From: Contact Centre (CRM) <contact@ribblevalley.gov.uk>
Sent: 13 March 2026 14:23
To: Planning
Subject: Planning Application Comments - 3/2026/0021 FS-Case-811928961

Planning Application Reference No.: 3/2026/0021

Address of Development: 41 - 43 Wellgate Clitheroe

Re: 3/2026/0021 - Change of use of upper floors to create four flats and external alterations - 41-43 Wellgate Clitheroe BB7 1LU

BACK ELEVATION (No Change proposed)
1:100 @ A3

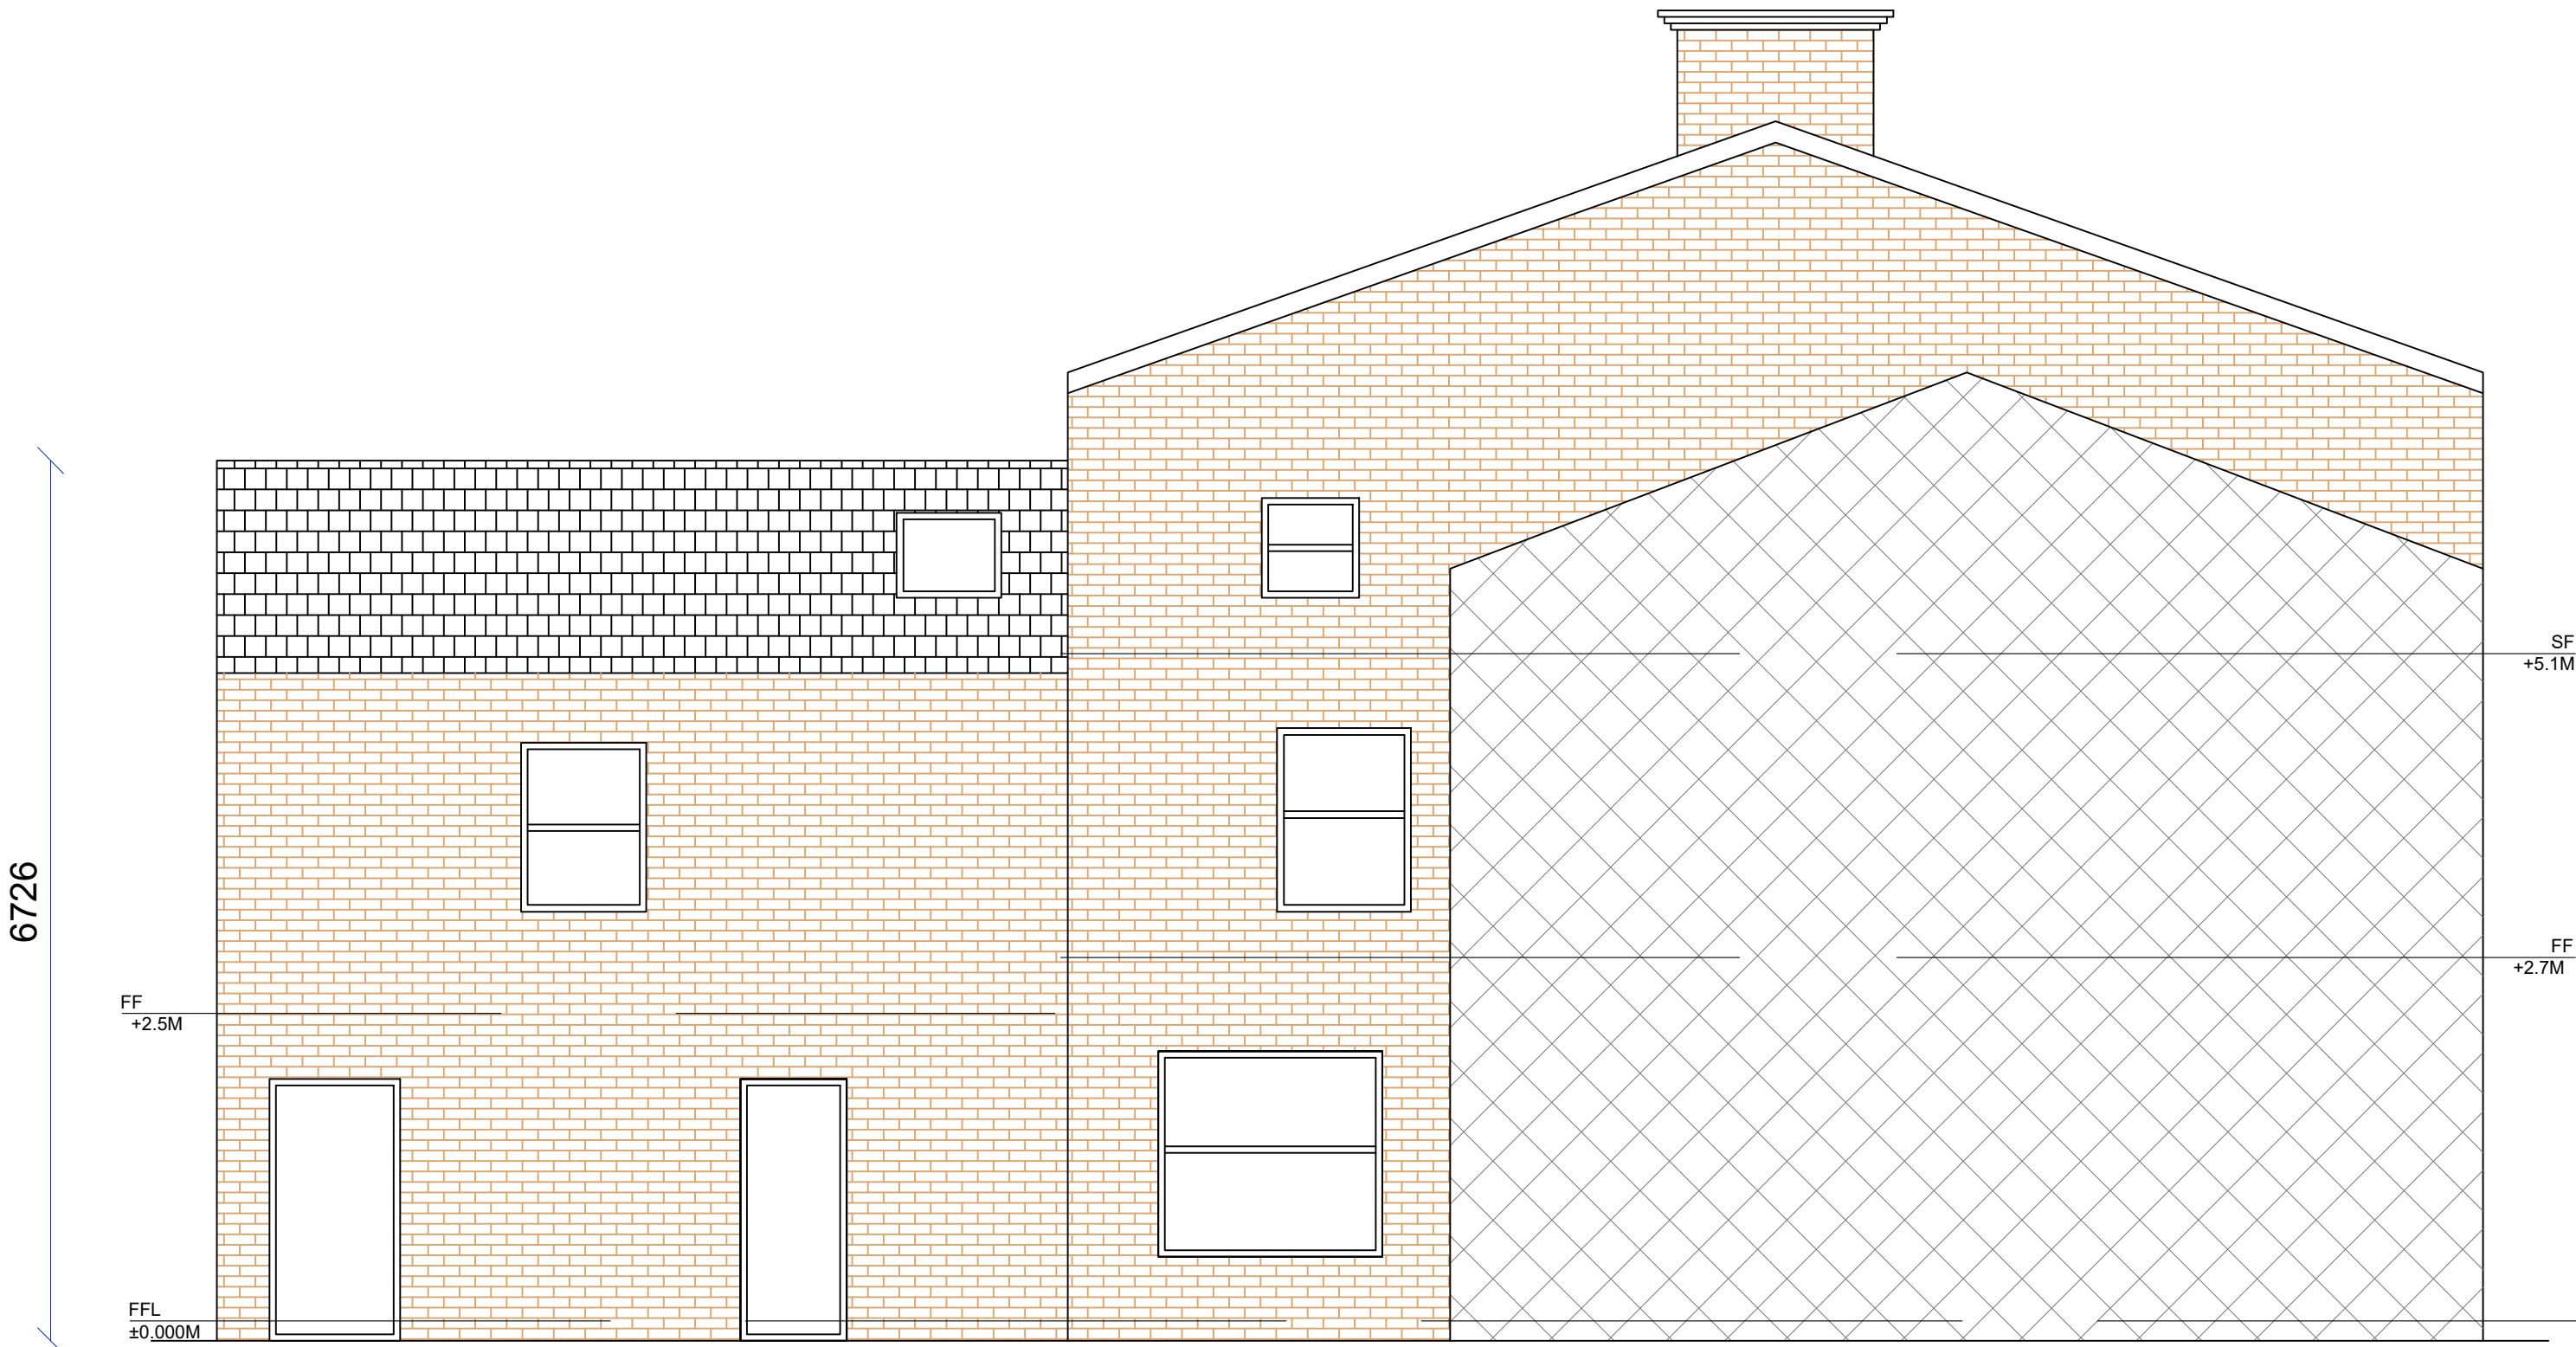
The Design and Access Statement refers to triple-glazed windows, while the Heritage Statement refers to the refurbishment of sliding sash windows, and the Acoustic Survey recommends standard double-glazed units.

Proposed elevation drawings do not show any changes to the windows. Clarity on the type of windows should be provided with the application. If double or triple-glazed units are proposed, then these should be of a style and materials appropriate for use in the conservation area to avoid harm to its significance and should be accompanied by sufficient justification.

SHEET:
Refuse plan

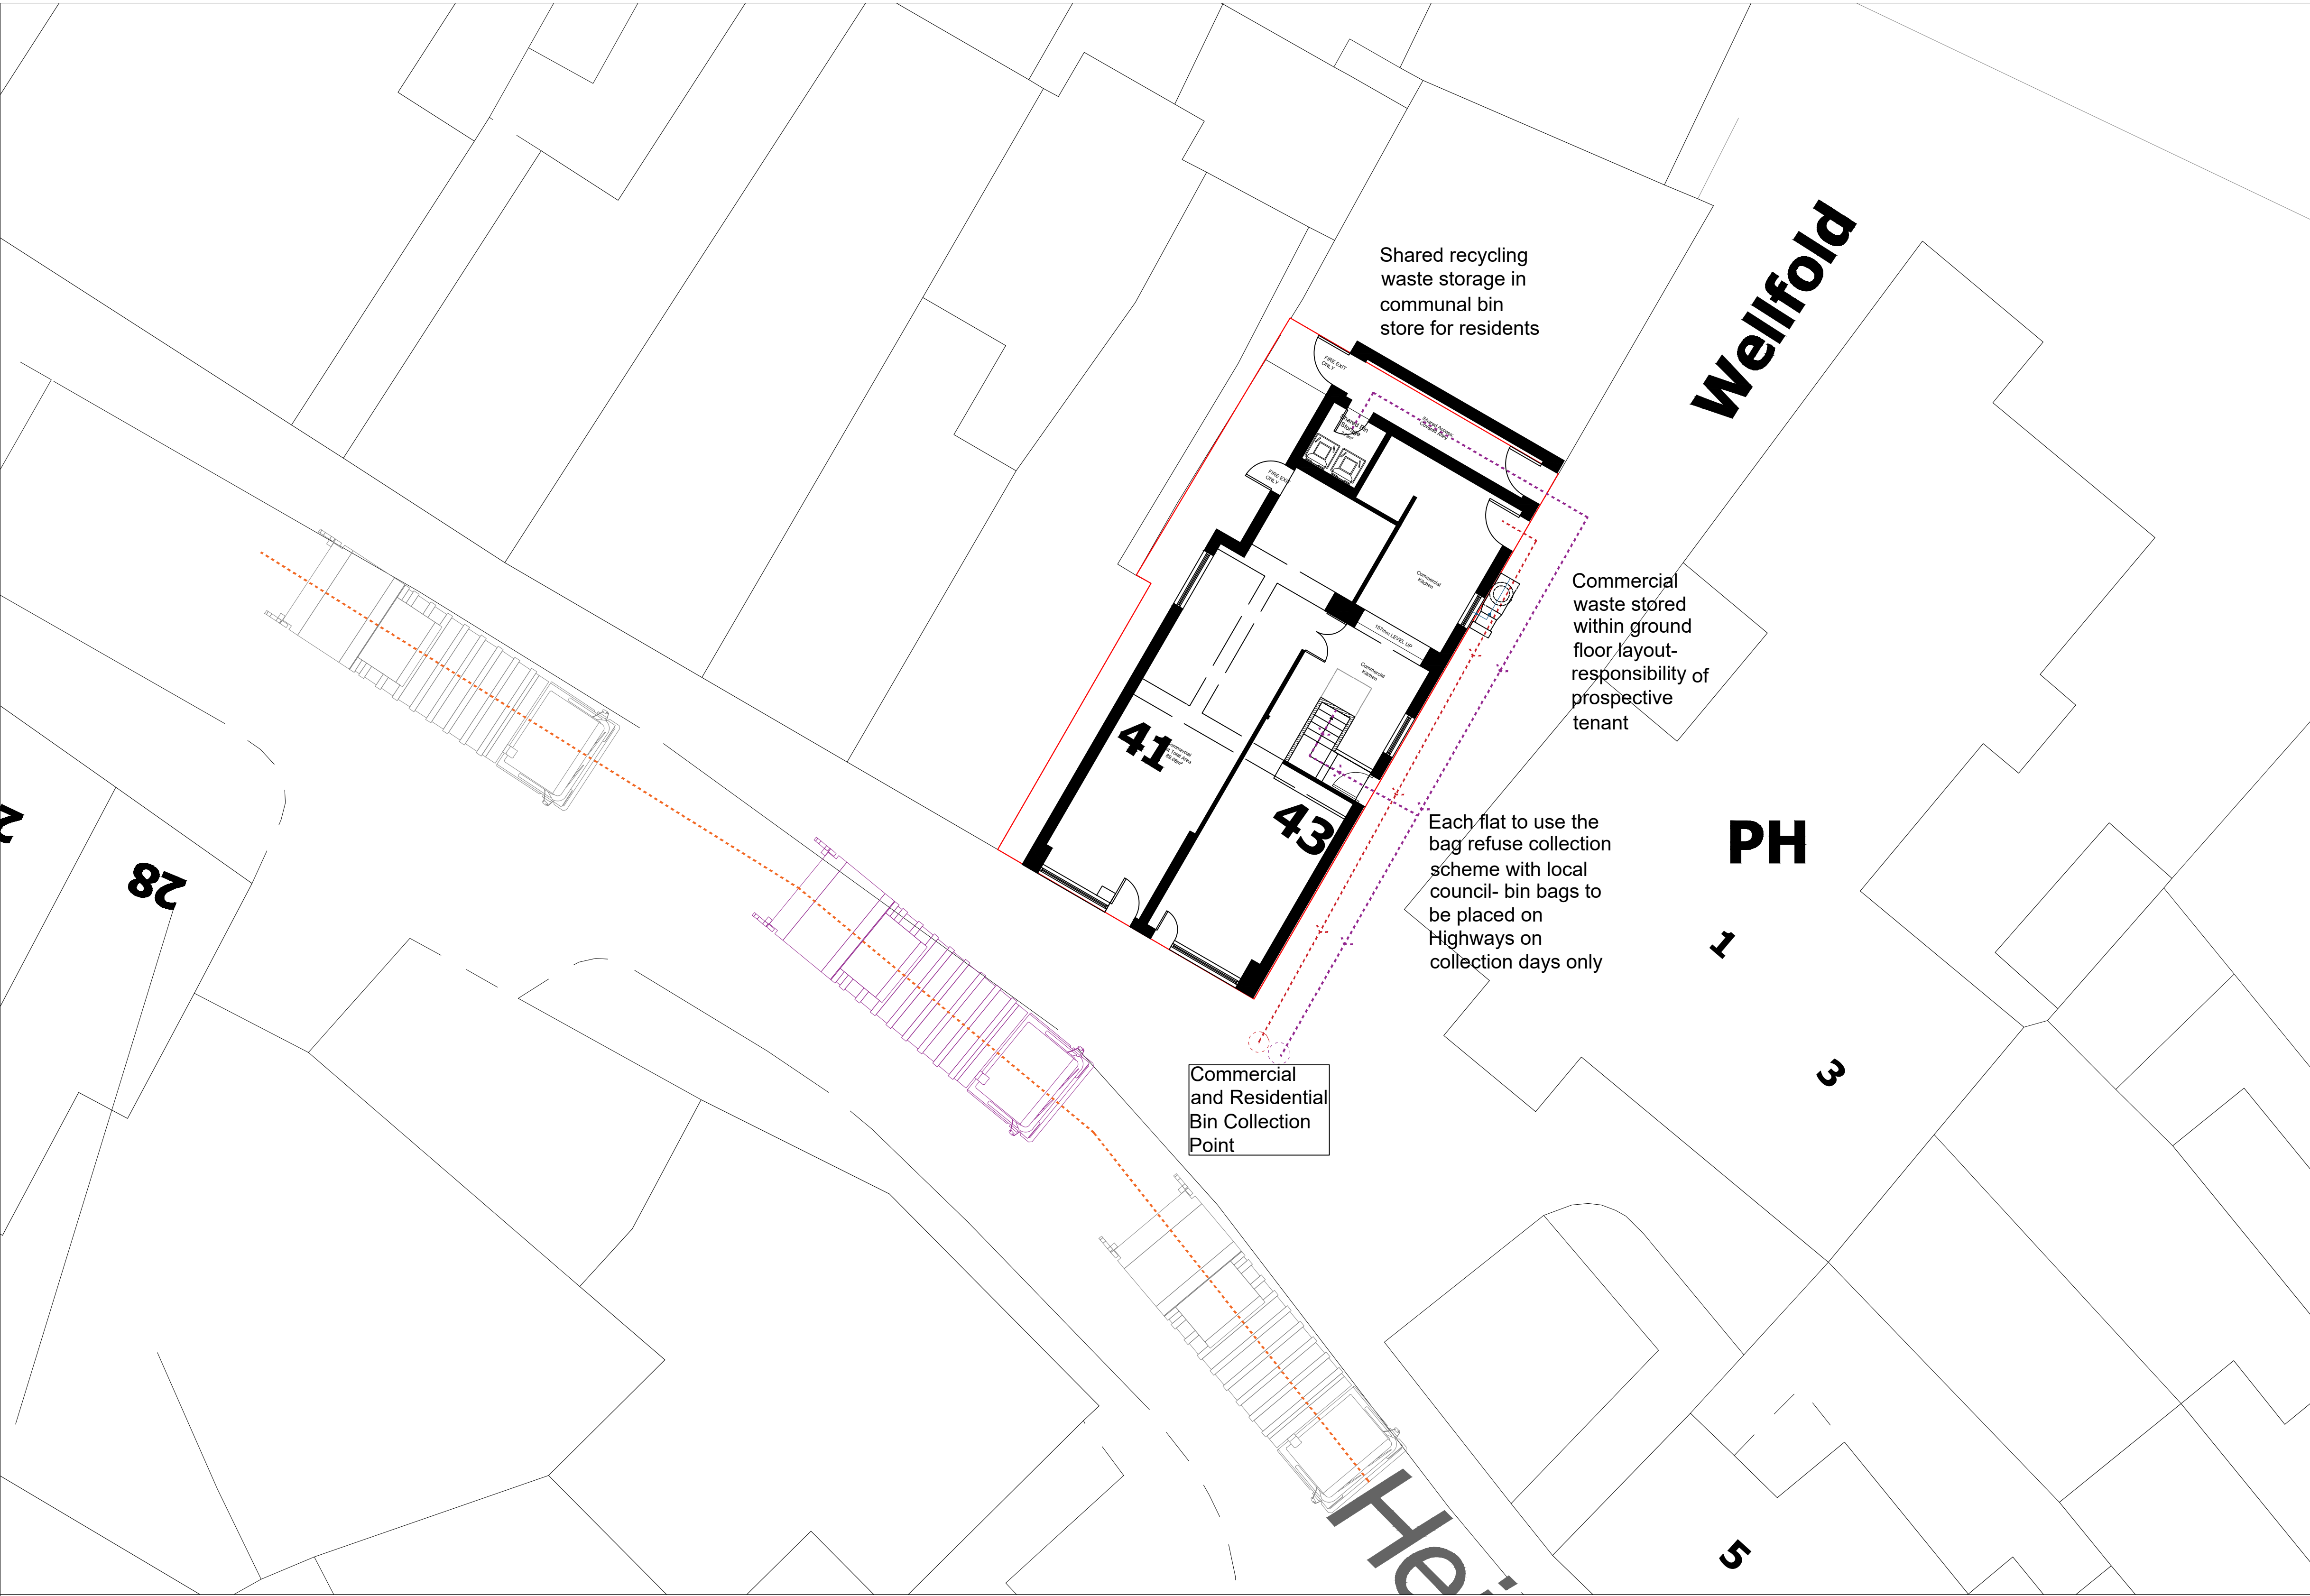
Whilst this application is an improvement on 3/2023/1011, making little change to the exterior and reducing the number of apartments to four, I still have concerns about overcrowding, the provisions for refuse storage and removal and also with the standard of work that can be expected.
